## **Application by Highways England for an Order Granting Development Consent for the M42 Junction 6 Improvement**

### **The Examining Authority's written questions and requests for information (ExQ2)**

**Issued on 5 August 2019**

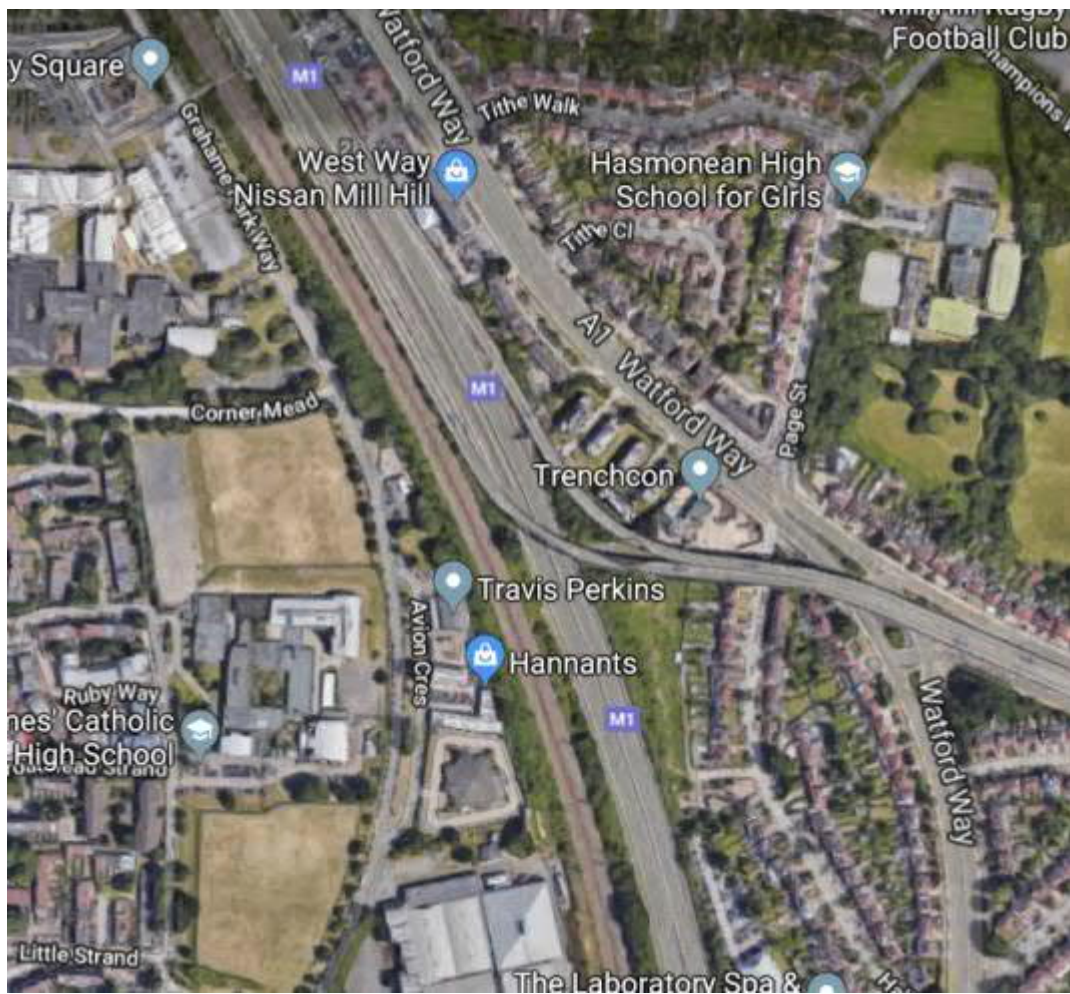
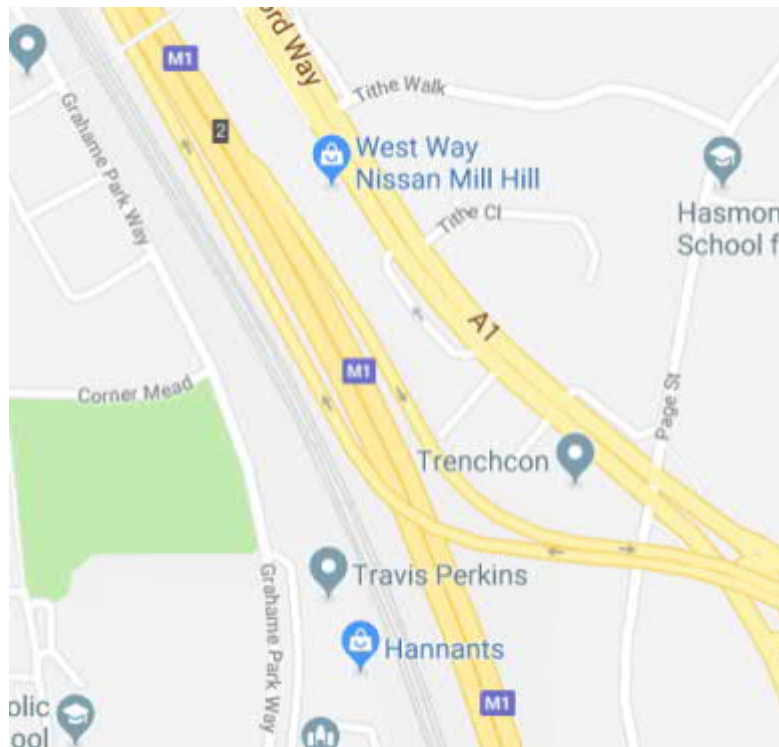
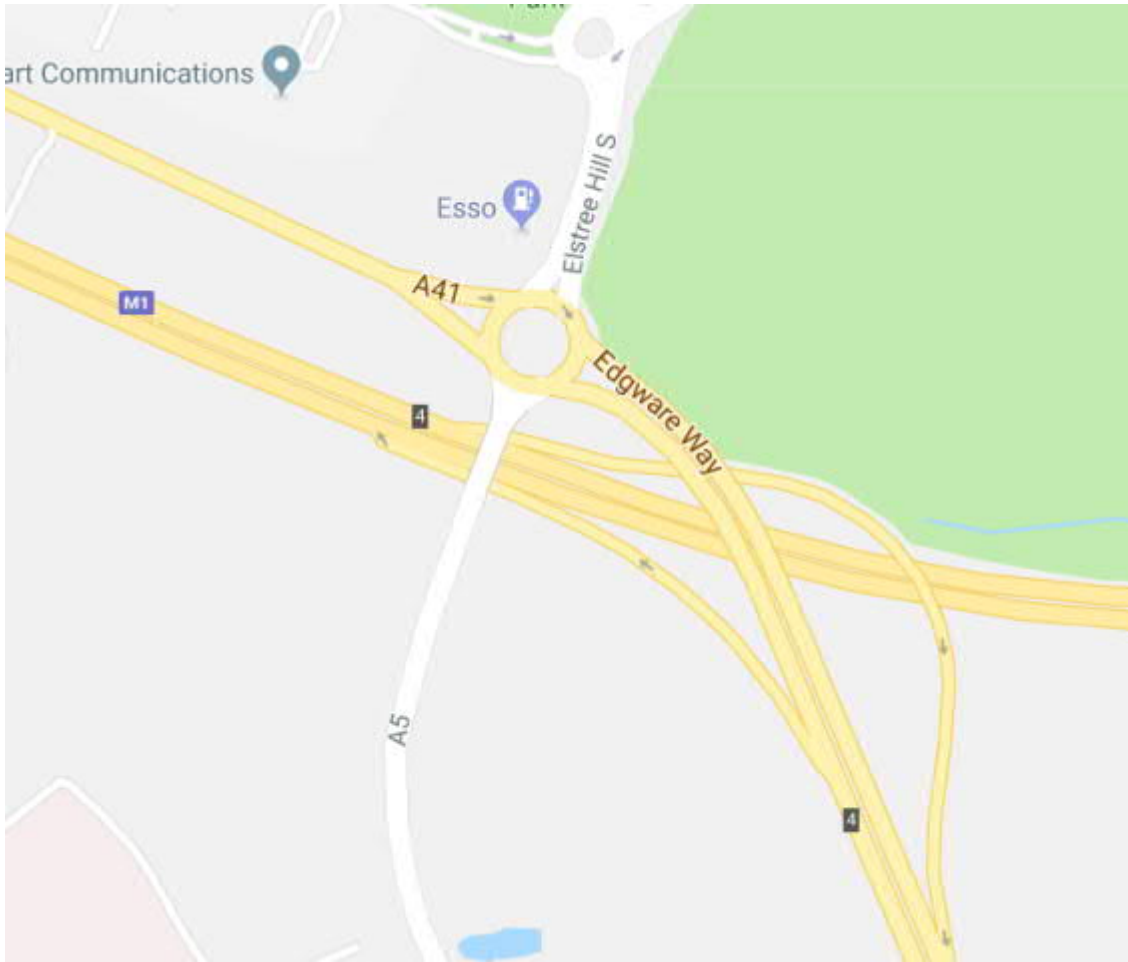
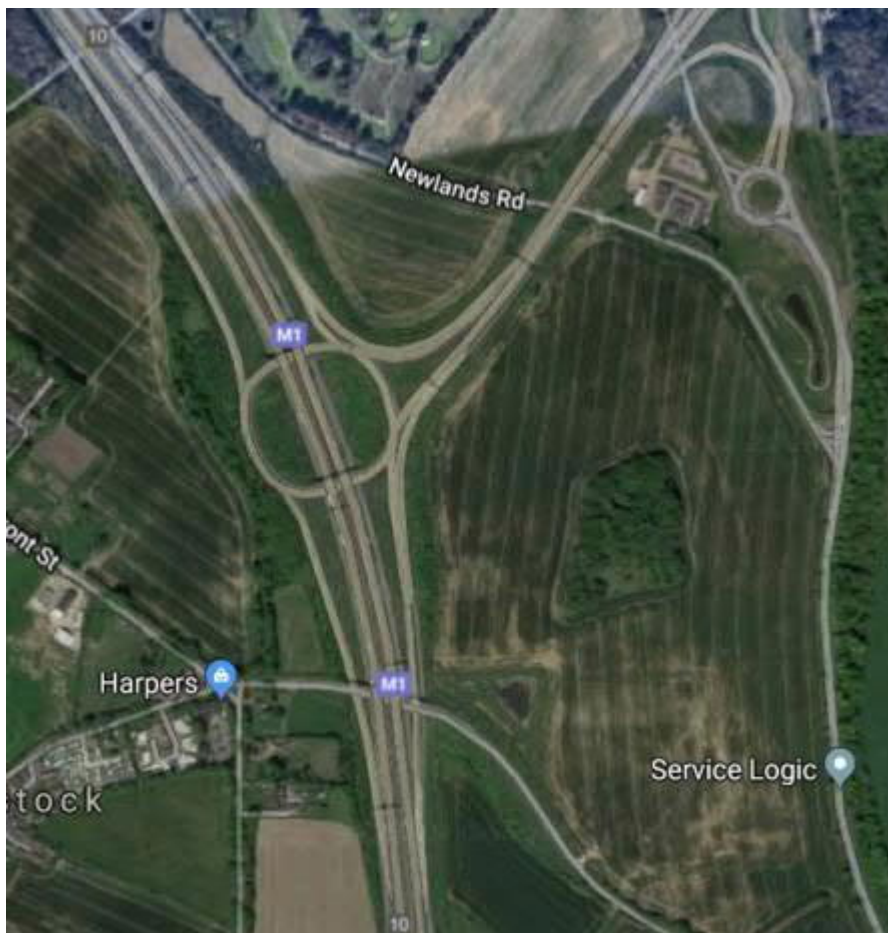
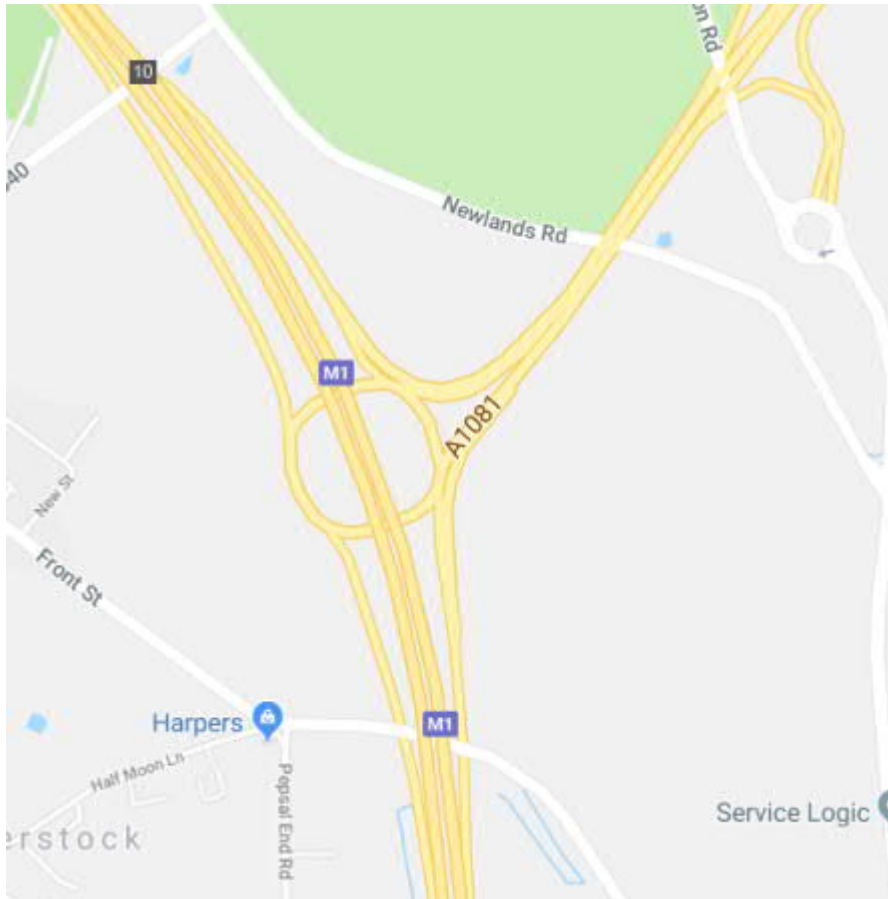
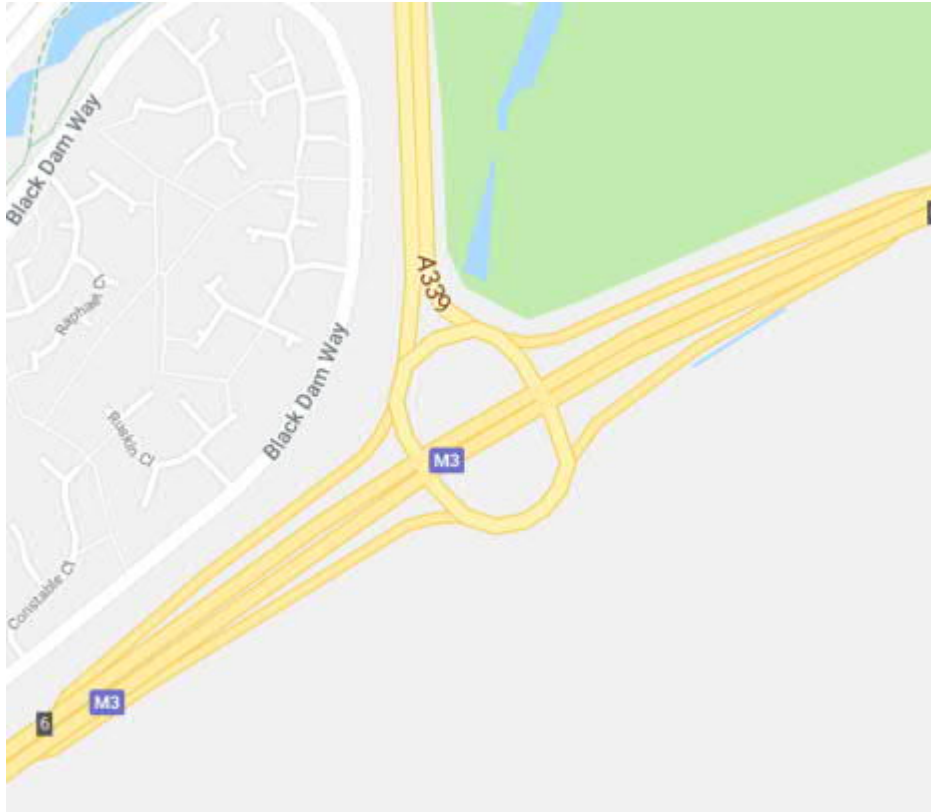
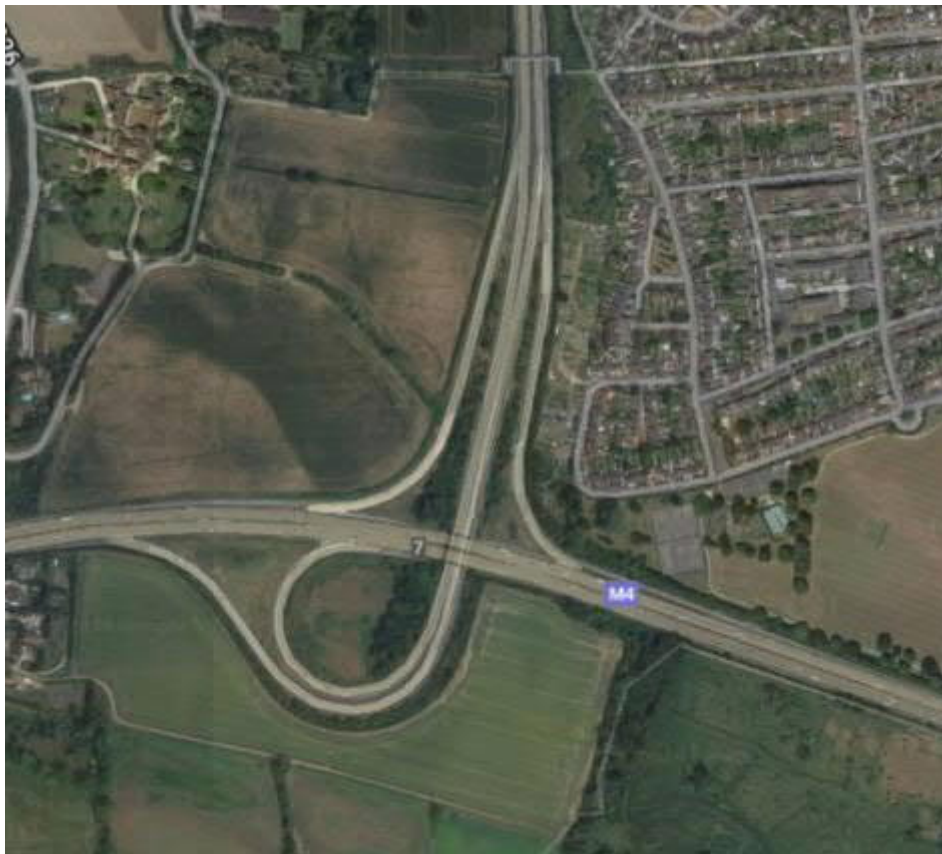
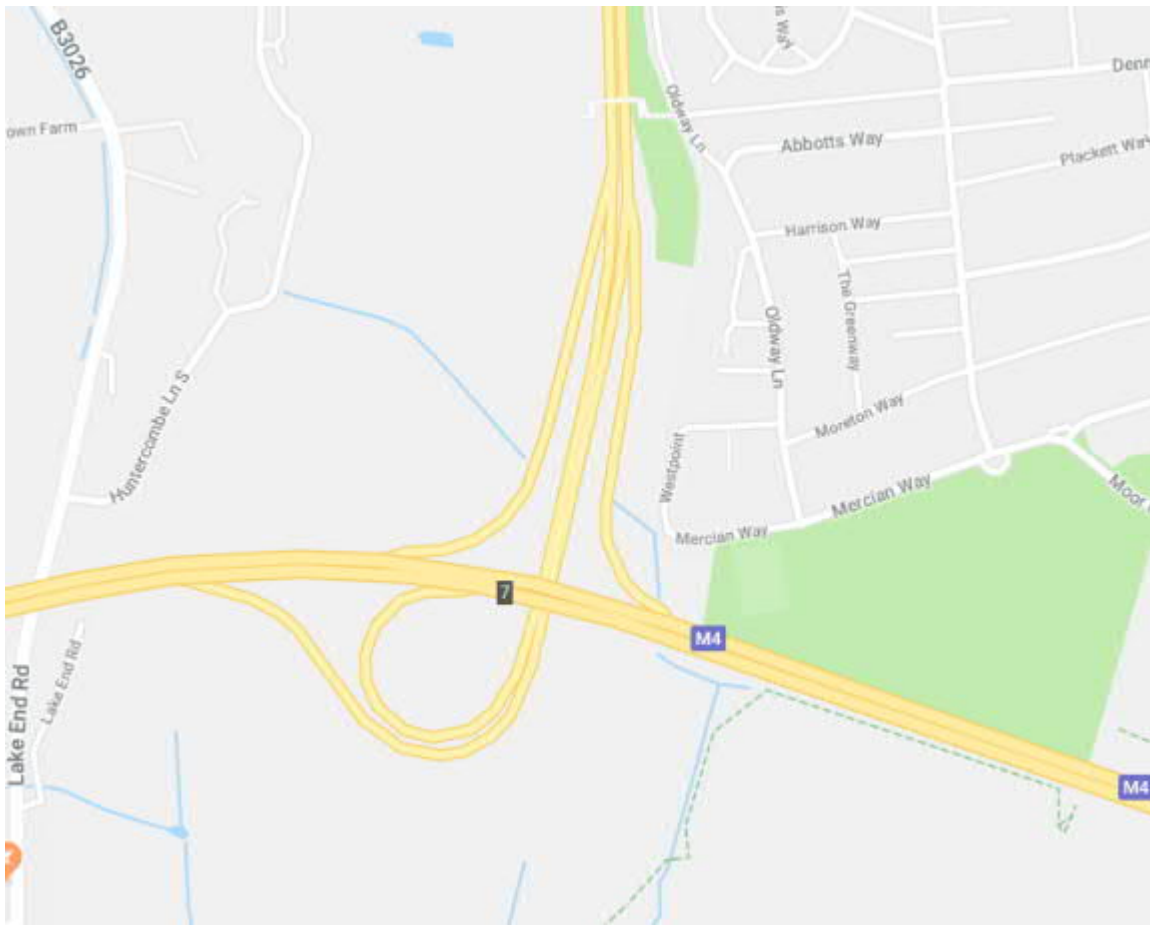
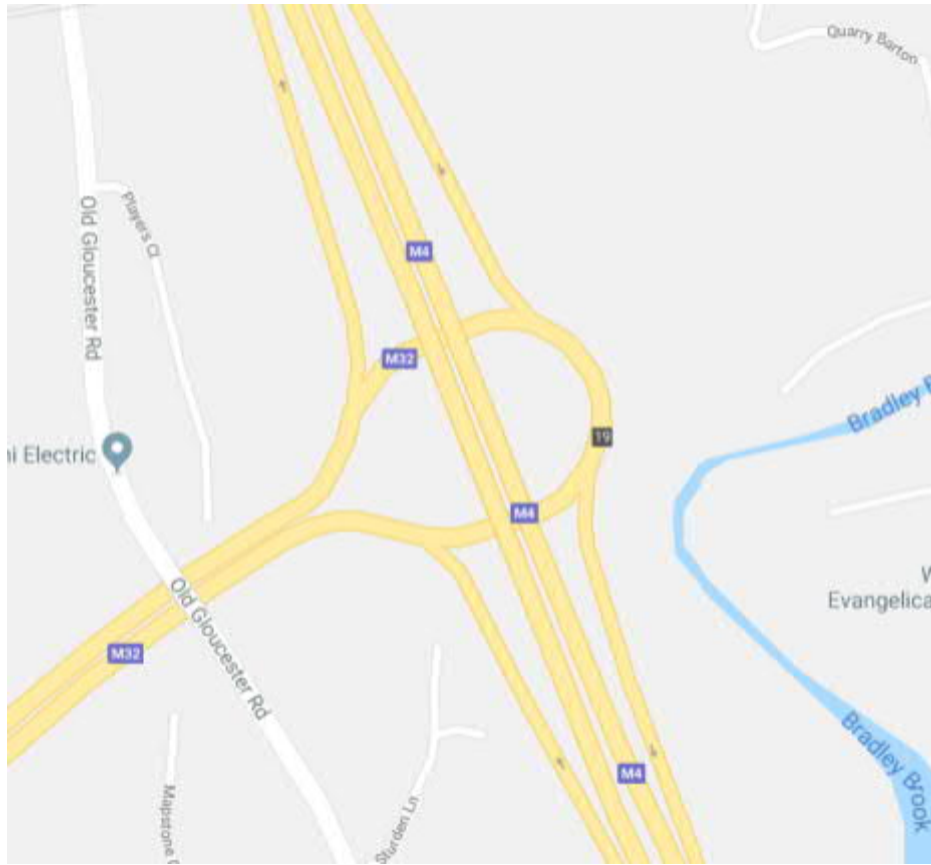
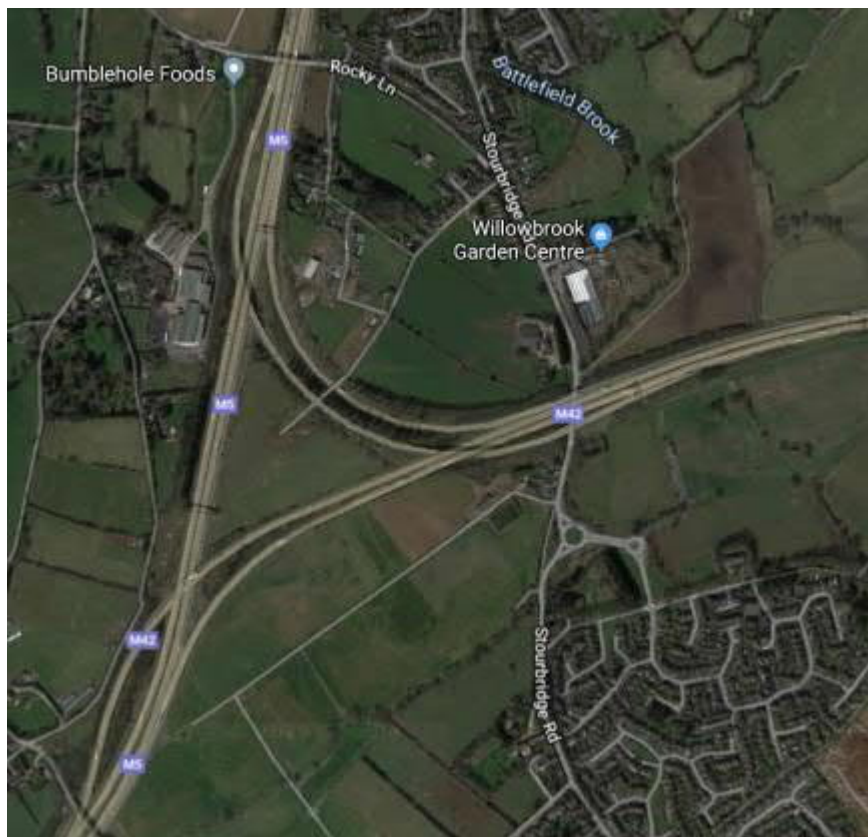
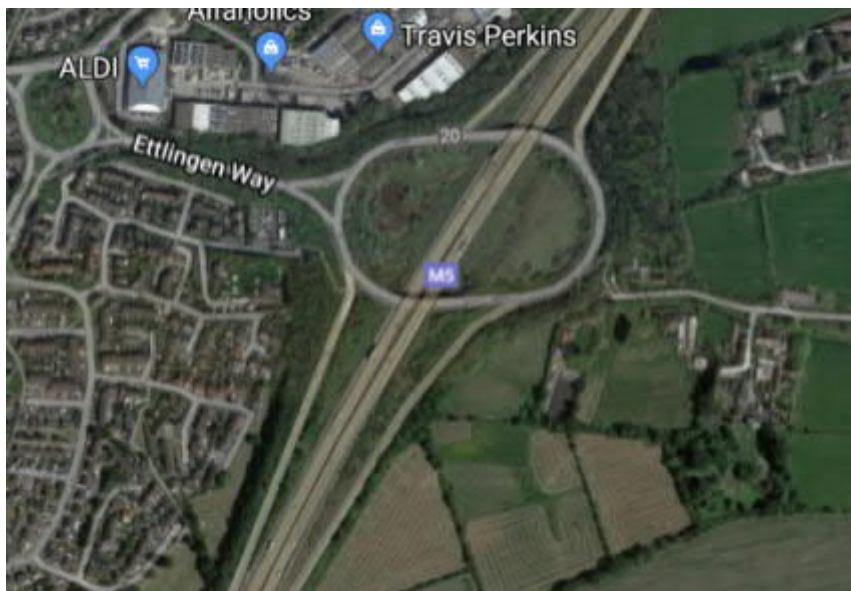
2.1.4.	The Applicant, SMBC, WCC, Extra MSA Solihull Ltd and Applegreen plc	<p><b>MSA and junction 5a</b>            It is evident from DMRB TD 22/06 figure 5/2 that the dumb-bell arrangement proposed would normally offer connections to 2-directional slip roads (in this case, N and S facing slips). How many junctions on English motorways are laid out in a dumb-bell arrangement but only with uni-directional slip roads?</p>
